From: Ian Brewster
Sent: 20 November 2013 14:58
To: Peter Cleveland
Subject: RE: EG/53/13/DOC - Brooks Nursery ref: Condition 7

From: Peter Cleveland
Sent: 19 November 2013 11:13
To: Ian Brewster
Subject: EG/53/13/DOC - Brooks Nursery ref: Condition 7

Further to our telephone conversation regarding the proposed planting screen along the west boundary of the site – please find attached the plans detailing the types of planting approved along this western boundary. Condition 7 of the approval requires us to agree/approve details of the position and maturity of planting along this boundary.

No development shall commence until details of the positions and maturity of planting along the eastern boundary of the site has been submitted to and approved by the Local Planning Authority. Plots 4, 7 and 8 - 13 shall not be occupied until such planting has been completed.

scheme: Brook Nursery,
Barnham
client: Barratt Homes
drawing: Landscape proposals
date: 13/11/2012
scale: 1:200@A1
drawing no: BSH18222 13B
drawn: DKM checked: AW

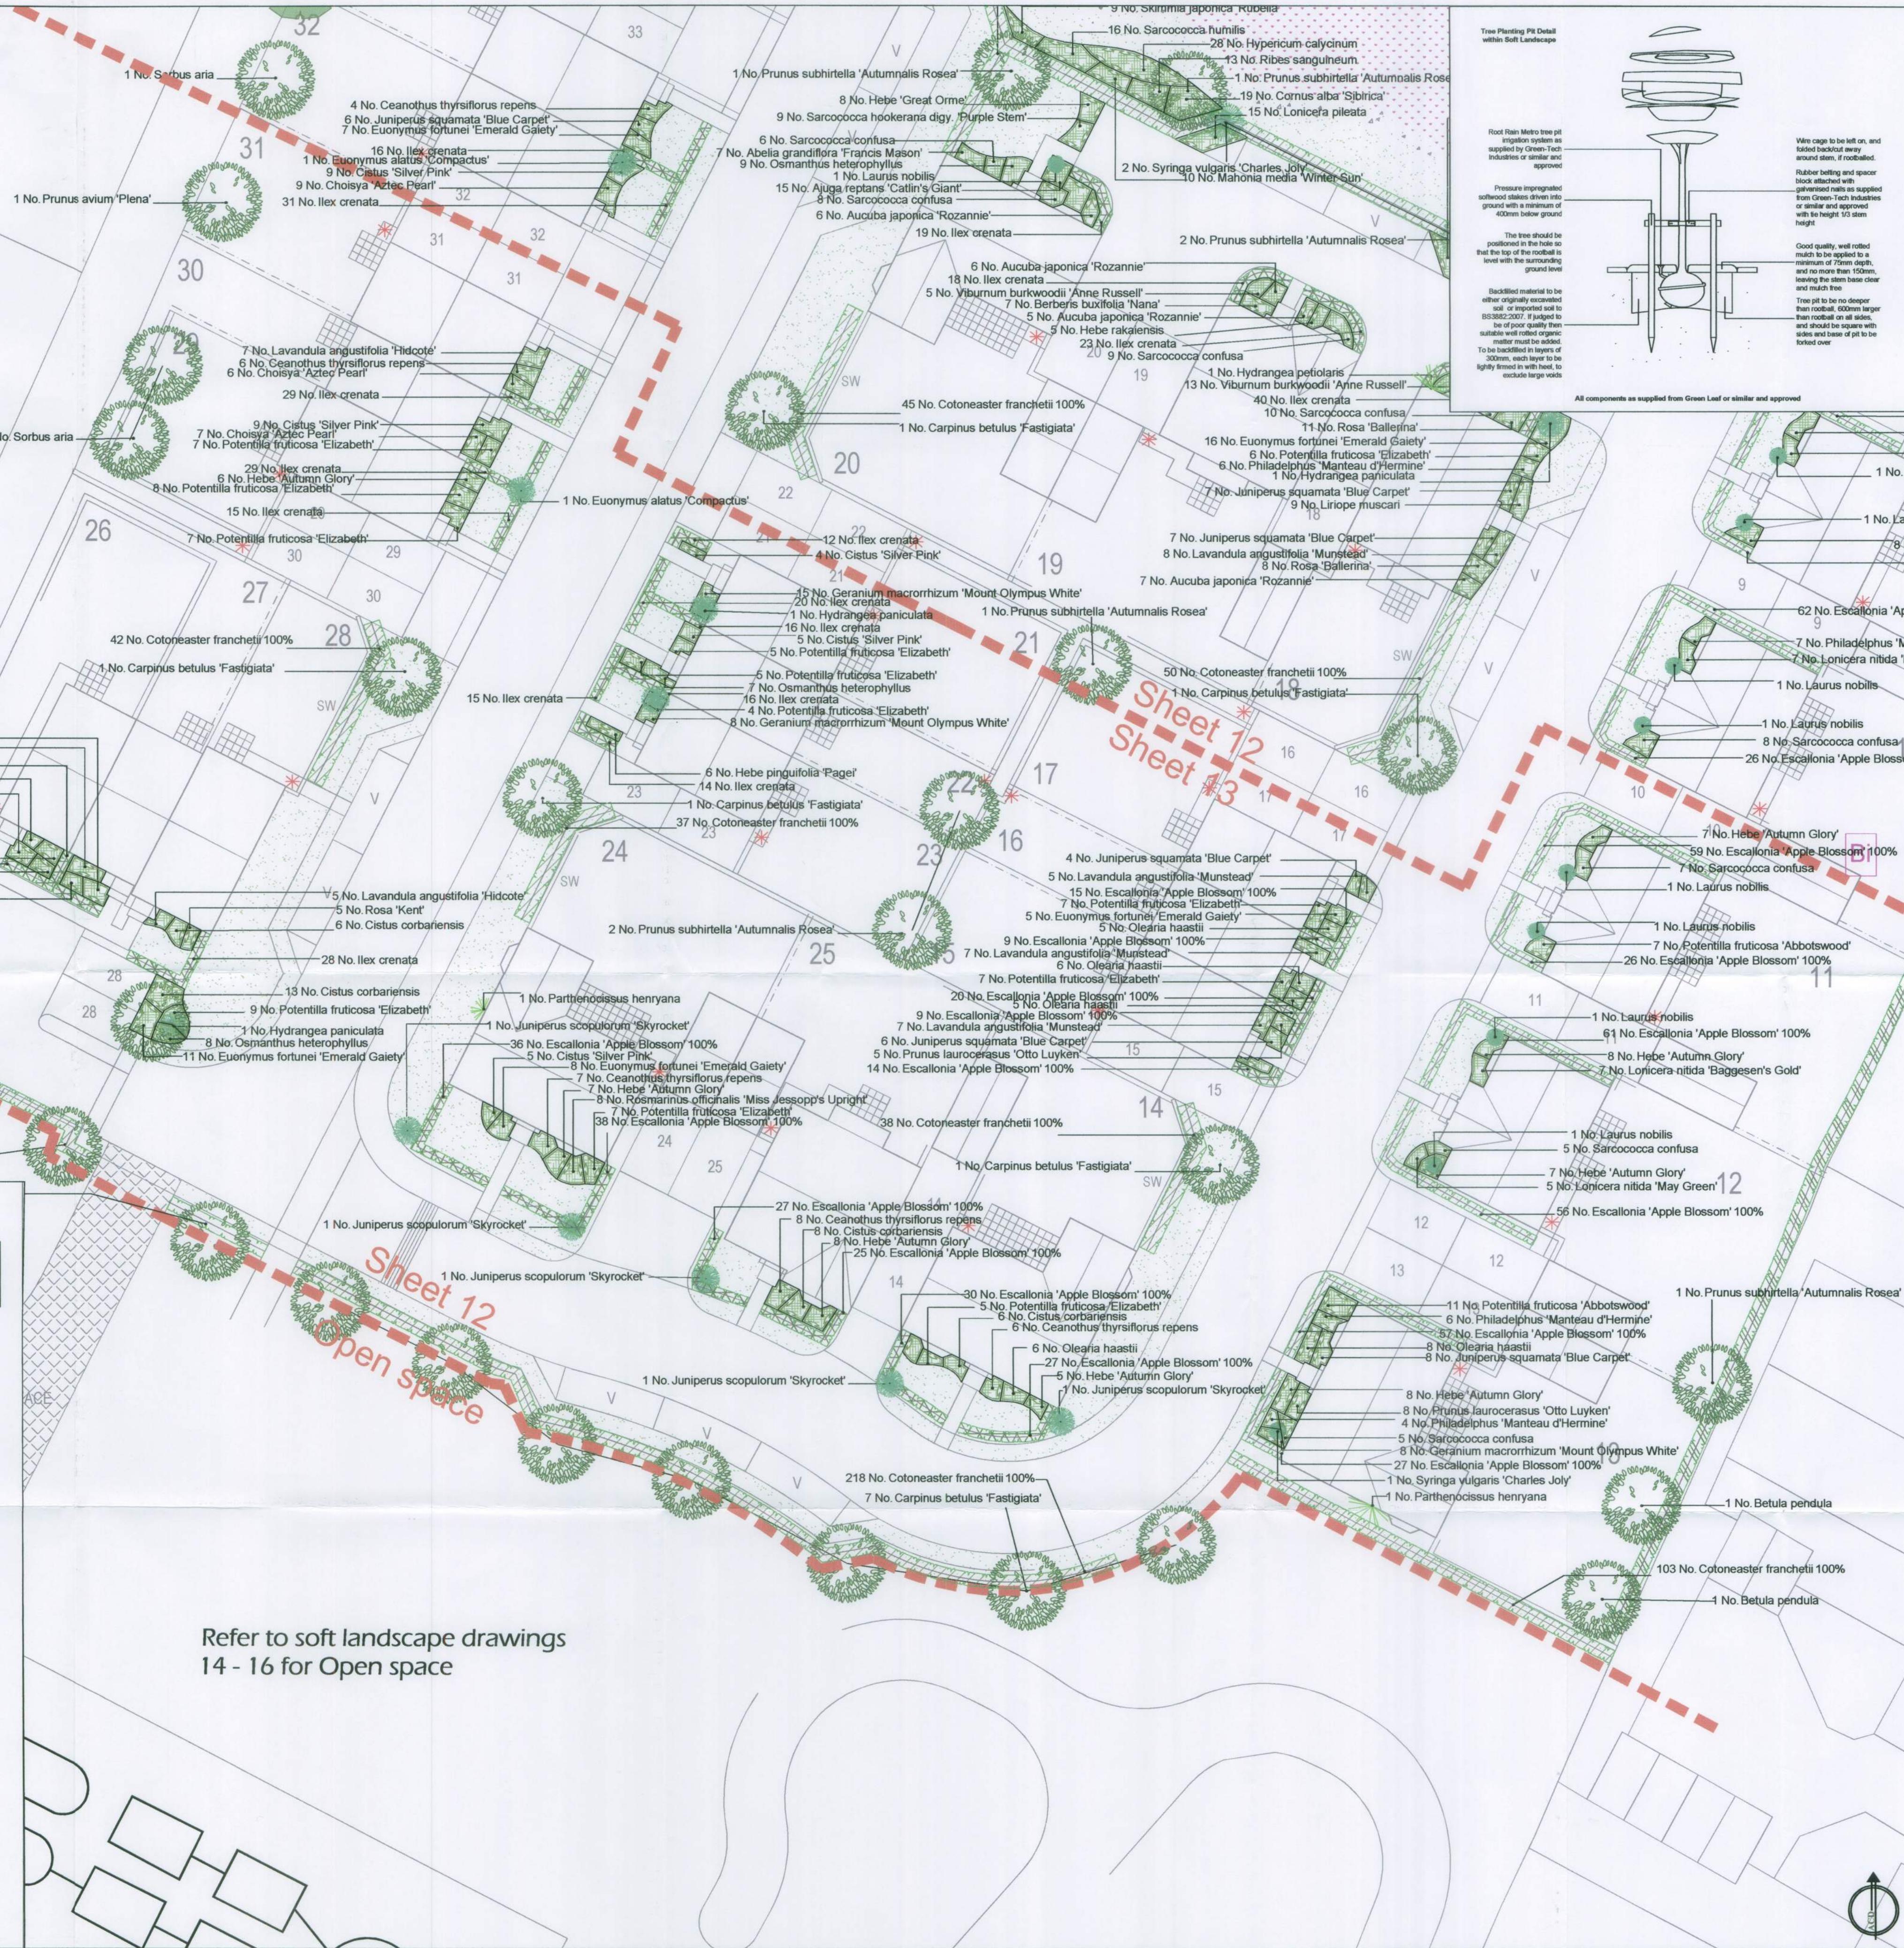
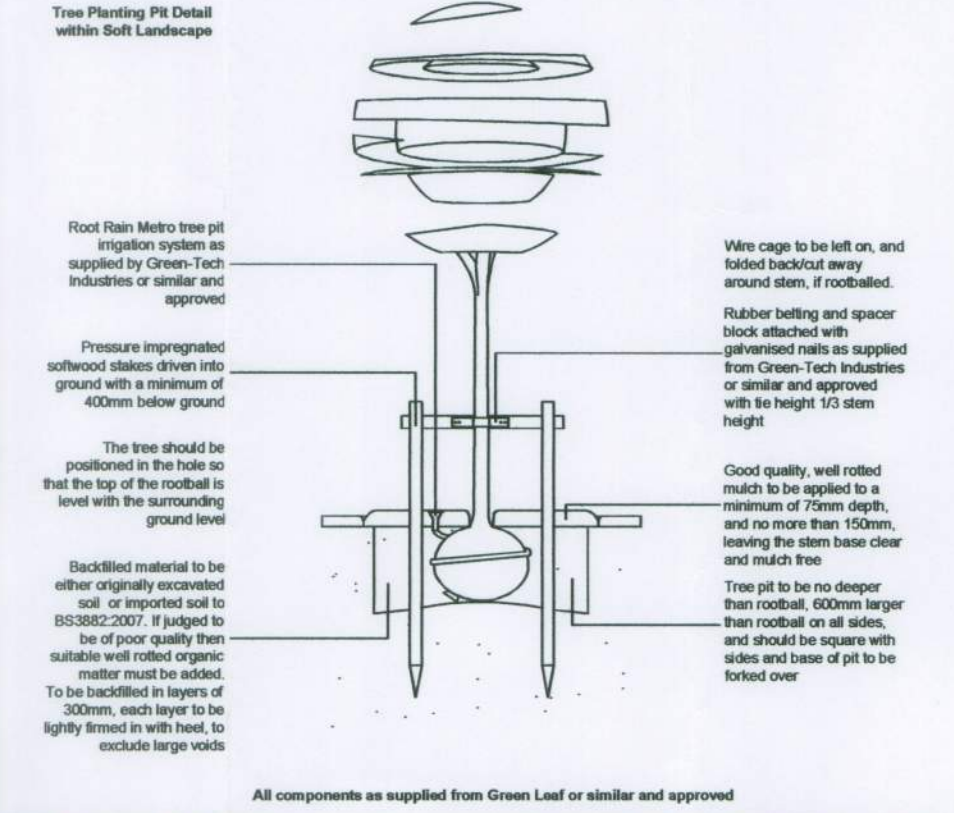
Yes this is specific to the plantings along the eastern boundary.

Yes good species mix (save for the escaped *Prunus subhirtella*) and acceptable. The area may require post care after planting using a hoe and not chemical herbicide until they can compete successfully after establishment say after 2-3yrs. After considering the screen idea this would appear not to be appropriate as the species choice should establish without environmental protection. However rabbits may become a pest and spiral tree guards should be considered (see : <http://www.wildlifefencing.co.uk/home.php?cat=70&gclid=CJTzj4Dz8LoCFfMctAodJhsArA>)
